**Ian Maguire**  
**Assistant Director Planning**  
**& Economic Growth**

Our Ref: 20201020

Date: 20/10/2020

**RE: Deadline 2 Submission in respect of the Application by AQUIND Limited for an Order granting Development Consent for the AQUIND Interconnector Project.**

Plate 2 – Typical Compound Area for Joint Bay

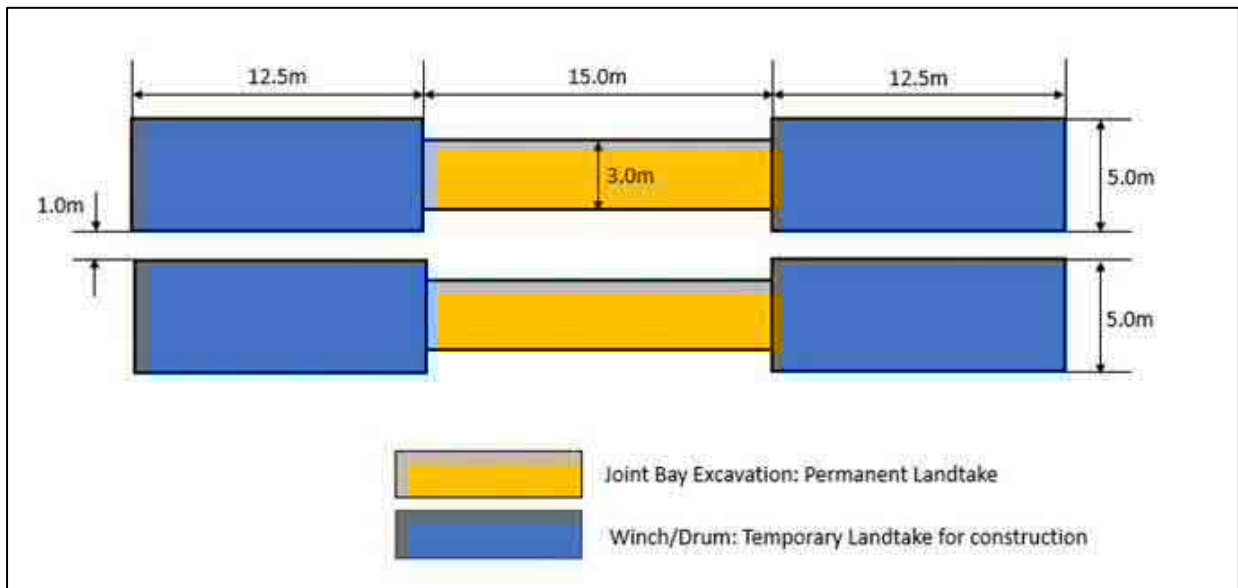
7. The LHA is not content with the optionality of joint bays being located outside of the carriageway where practical. It is essential that the LHA has clarity over the route and joint bay locations to be able properly to assess the impact of the construction of the interconnector.
